Application Comment Report

Application No. LUPL-25-0008

Record Type : Land Use Plan

Document: 241010_BLR Village C Land Use Plan.pdf

ISSUE RECORD

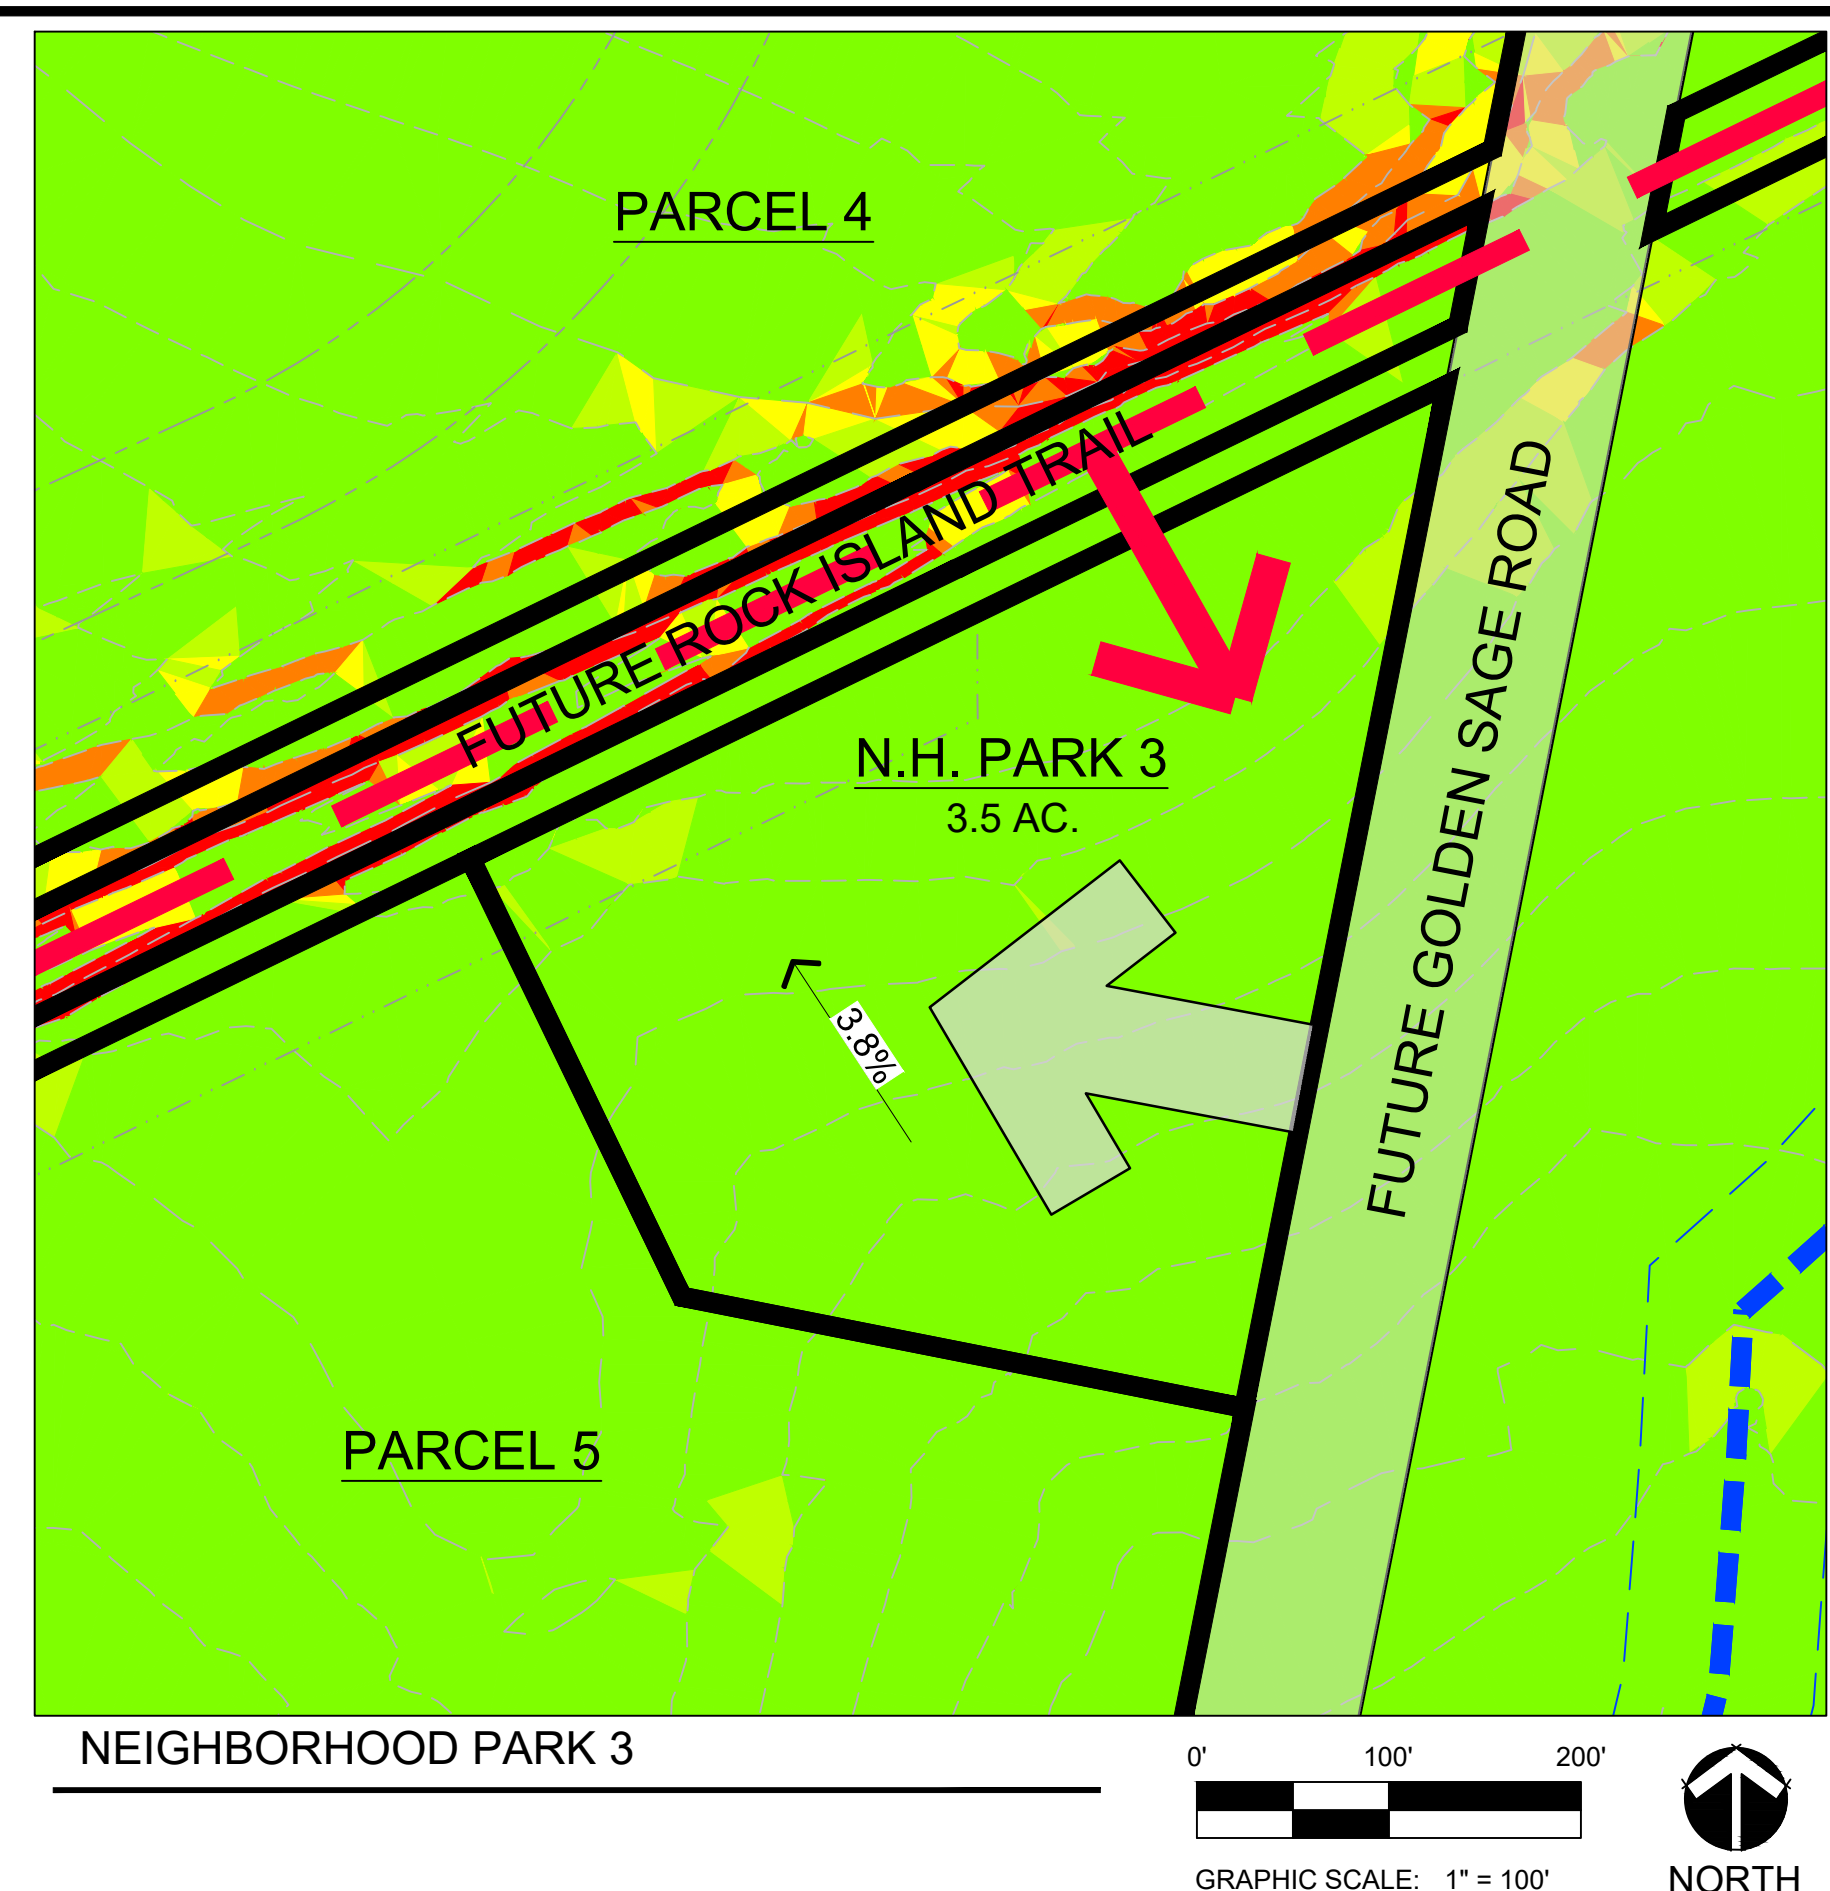
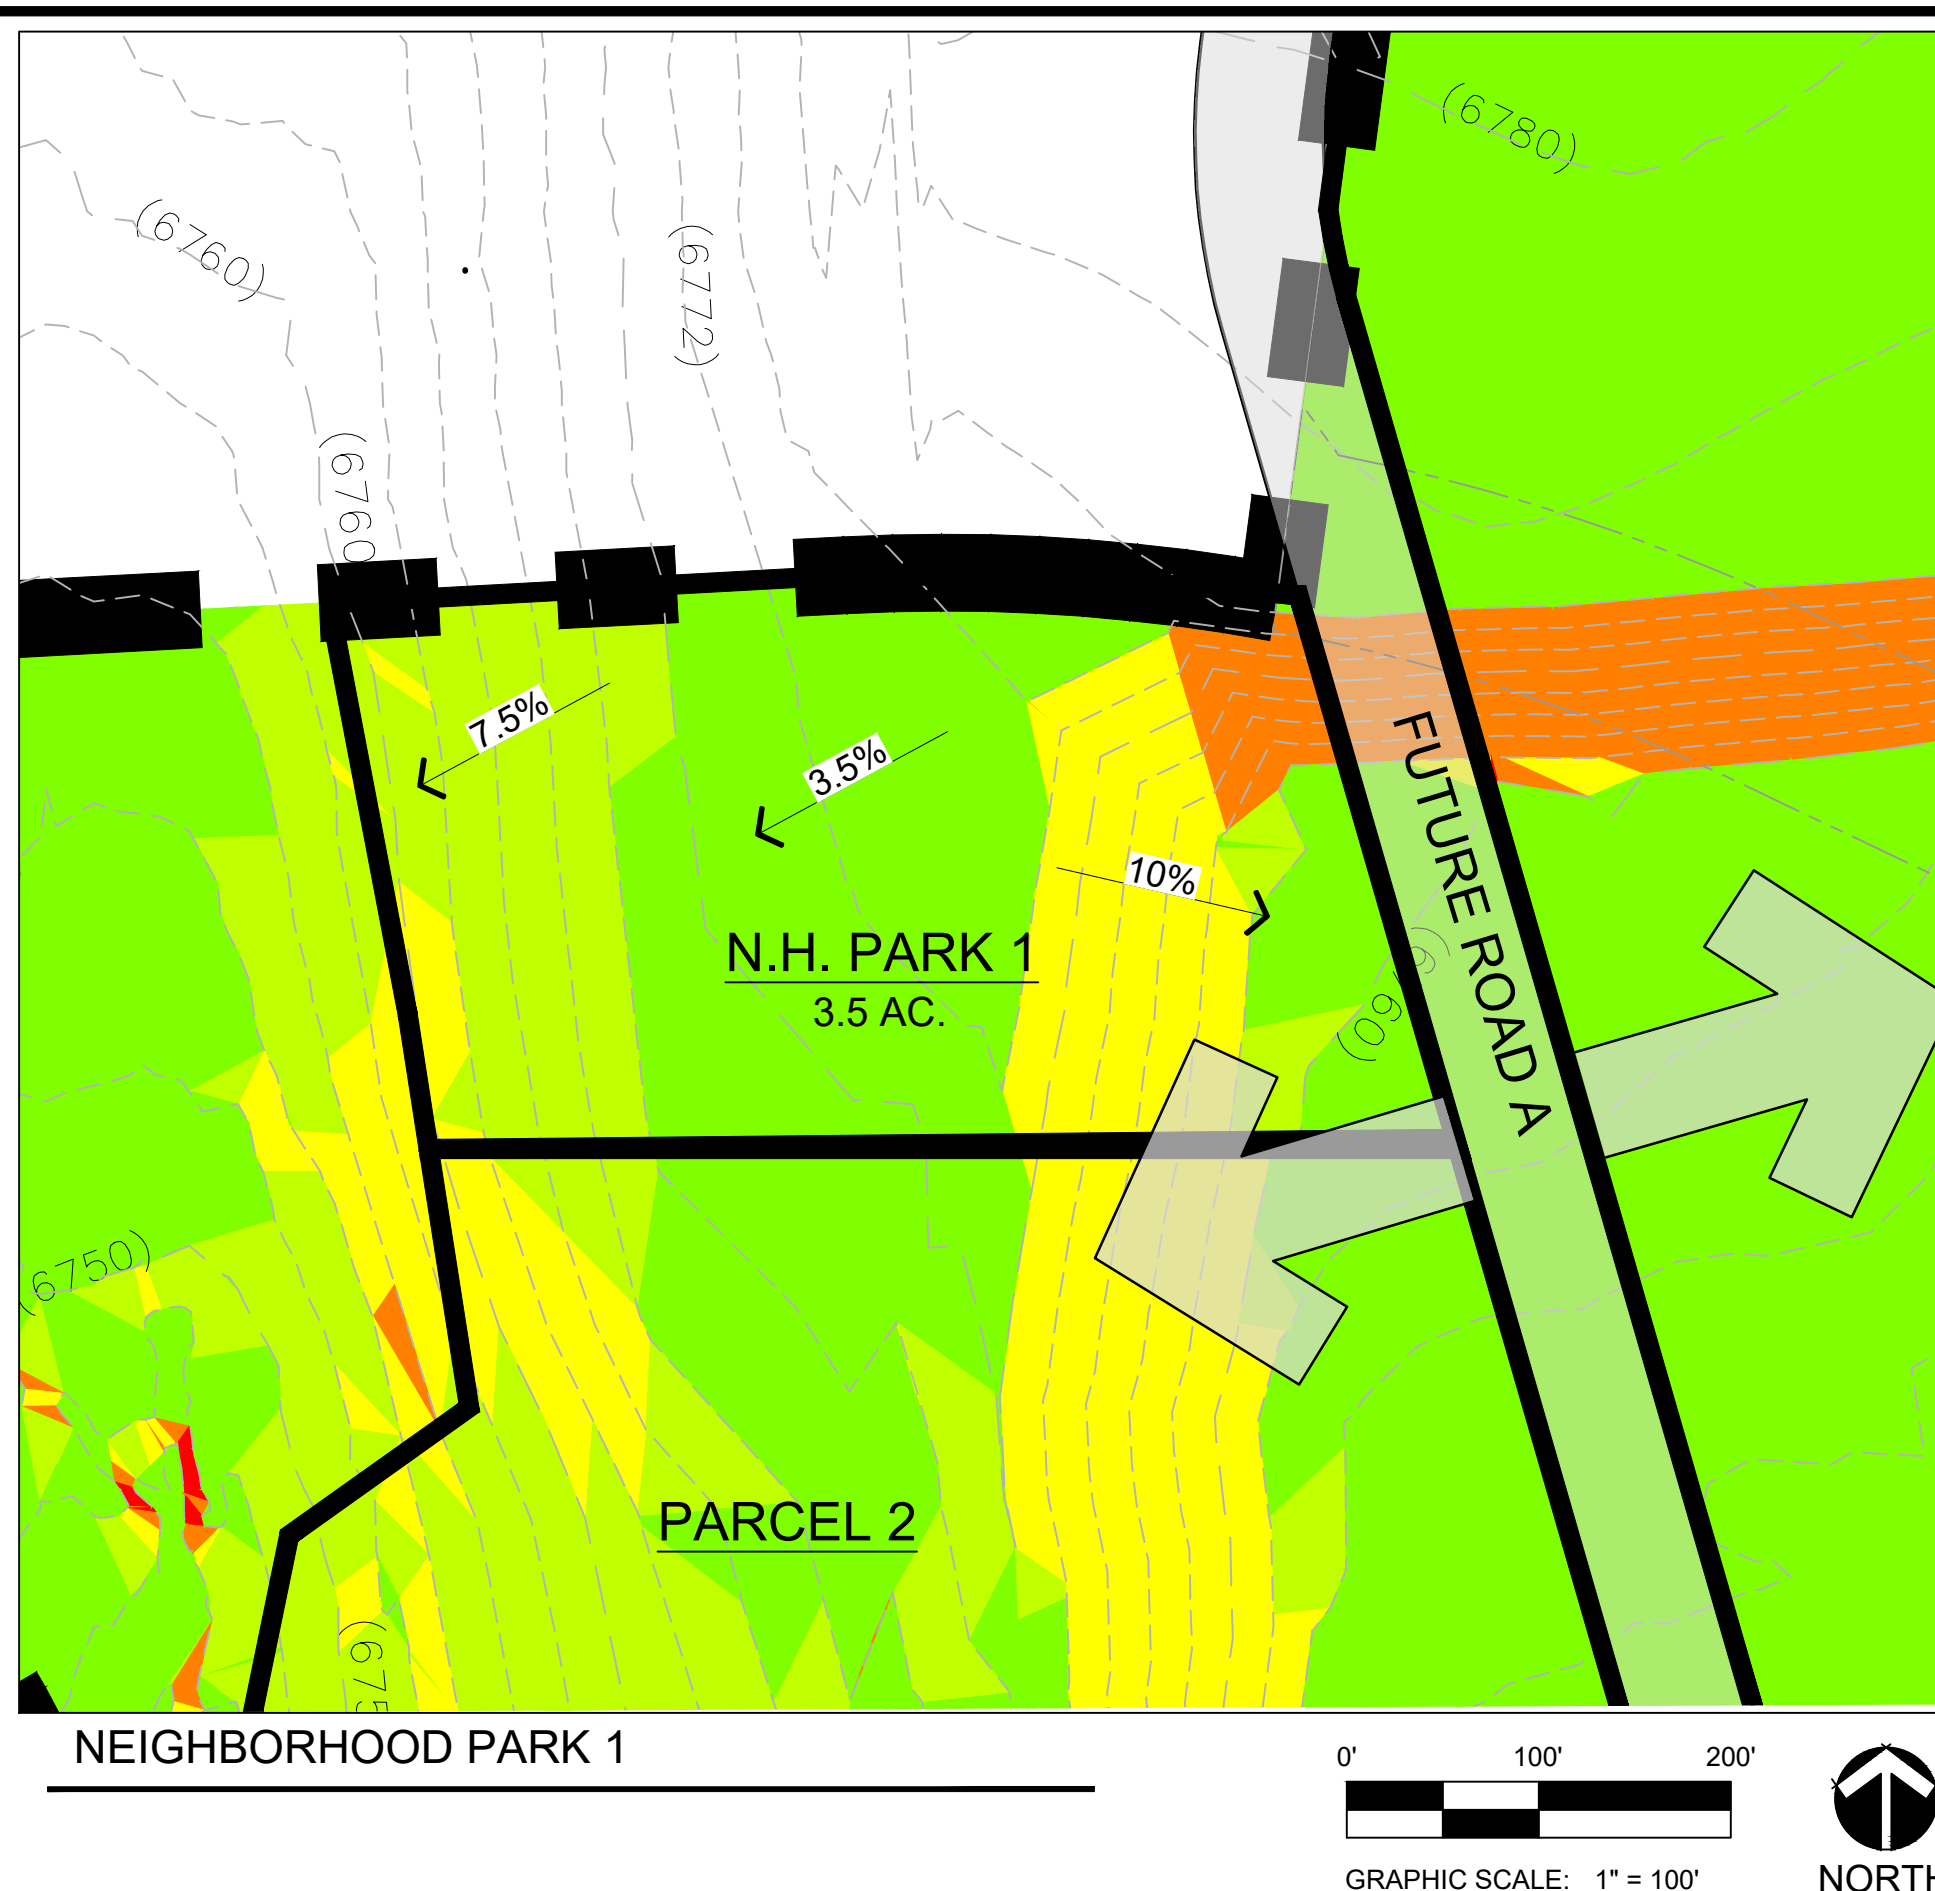
| Comment ID | Page Reference | Annotation Type | Reviewer : Department | Status | Review Comments | Applicant Response Comments |
|------------|----------------|-----------------|--|--------|---|--|
| 2 | 2 | Note | Zaker Alazzeh : City Eng - Traffic Engineering | Open | The developer shall dedicate the appropriate right-of-way along the northern property line of Parcel 6, located on Dublin Boulevard. This dedication must align with the western property line right-of-way existing roadway and meet the city's standards. Please coordinate with city traffic engineering on the ROW dedication. | <p>Guest - 10-28-2025 15:04:11</p> <p>Dublin Blvd north of Parcel 7 now has a 70' ROW per the 9/8/2025 meeting with Oakwood, LAI, Classic Consulting, City Traffic, and El Paso County Engineer.</p> |

| Comment ID | Page Reference | Annotation Type | Reviewer : Department | Status | Review Comments | Applicant Response Comments |
|------------|----------------|-----------------|----------------------------|--------|---|---|
| 70 | 2 | Note | Caroline Miller : Planning | Open | Please revise cells to match above unit counts. | |

| Comment ID | Page Reference | Annotation Type | Reviewer : Department | Status | Review Comments | Applicant Response Comments |
|------------|----------------|-----------------|----------------------------|--------|---|--|
| 71 | 2 | Note | Caroline Miller : Planning | Open | <p>With the change to Community Park acreage, staff would like to understand the road connections for the Community Park site and the residential area to the south. What is the thought for the road design? Will a connector road be built through the Community Park site, connecting to the residential area, thereby limiting the Community Park acreage to a full-access public road?</p> <p>In addition, will there be any other road access points off of Dublin, or just the Community Park area? Feel free to reach out to the reviewer to discuss in a meeting if preferred.</p> | <p>Guest - 10-28-2025 15:17:40</p> <p>Noted and a meeting with parks will be scheduled at the appropriate time.</p> |
| 75 | 2 | Callout | Tamara Baxter : Planning | Open | <p>What is the zoning for this area? Please call out.</p> | <p>Guest - 10-28-2025 15:22:33</p> <p>Zoning label added.</p> |
| 76 | 2 | Callout | Tamara Baxter : Planning | Open | <p>Please call out zoning for this area.</p> | <p>Guest - 10-28-2025 15:17:59</p> <p>Zoning label added.</p> |
| 77 | 2 | Callout | Tamara Baxter : Planning | Open | <p>Please call out zoning for this area. Should be reflective of the area shown in ZONE-25-0020</p> | <p>Guest - 10-28-2025 15:22:44</p> <p>Zoning label added.</p> |
| 78 | 2 | Callout | Tamara Baxter : Planning | Open | <p>Please call out zoning for this area. Should be reflective of ZONE-25-0021</p> | <p>Guest - 10-28-2025 15:21:01</p> <p>Zoning label added.</p> |

| Comment ID | Page Reference | Annotation Type | Reviewer : Department | Status | Review Comments | Applicant Response Comments |
|------------|----------------|-----------------|----------------------------|--------|---|---|
| 81 | 2 | Callout | Tamara Baxter : Planning | Open | As noted on the cover sheet, SF detached are conditional use in the MX-M zone district | Guest - 10-28-2025 15:23:14 SF detached is now identified as a conditional use in the table. |
| 83 | 2 | Note | Tamara Baxter : Planning | Open | Please clean up overlap so text is legible. | |
| 88 | 2 | Callout | Tamara Baxter : Planning | Open | Will future residential in this area be limited to the 3-156 du/ac, similar to R-Flex Med? | |
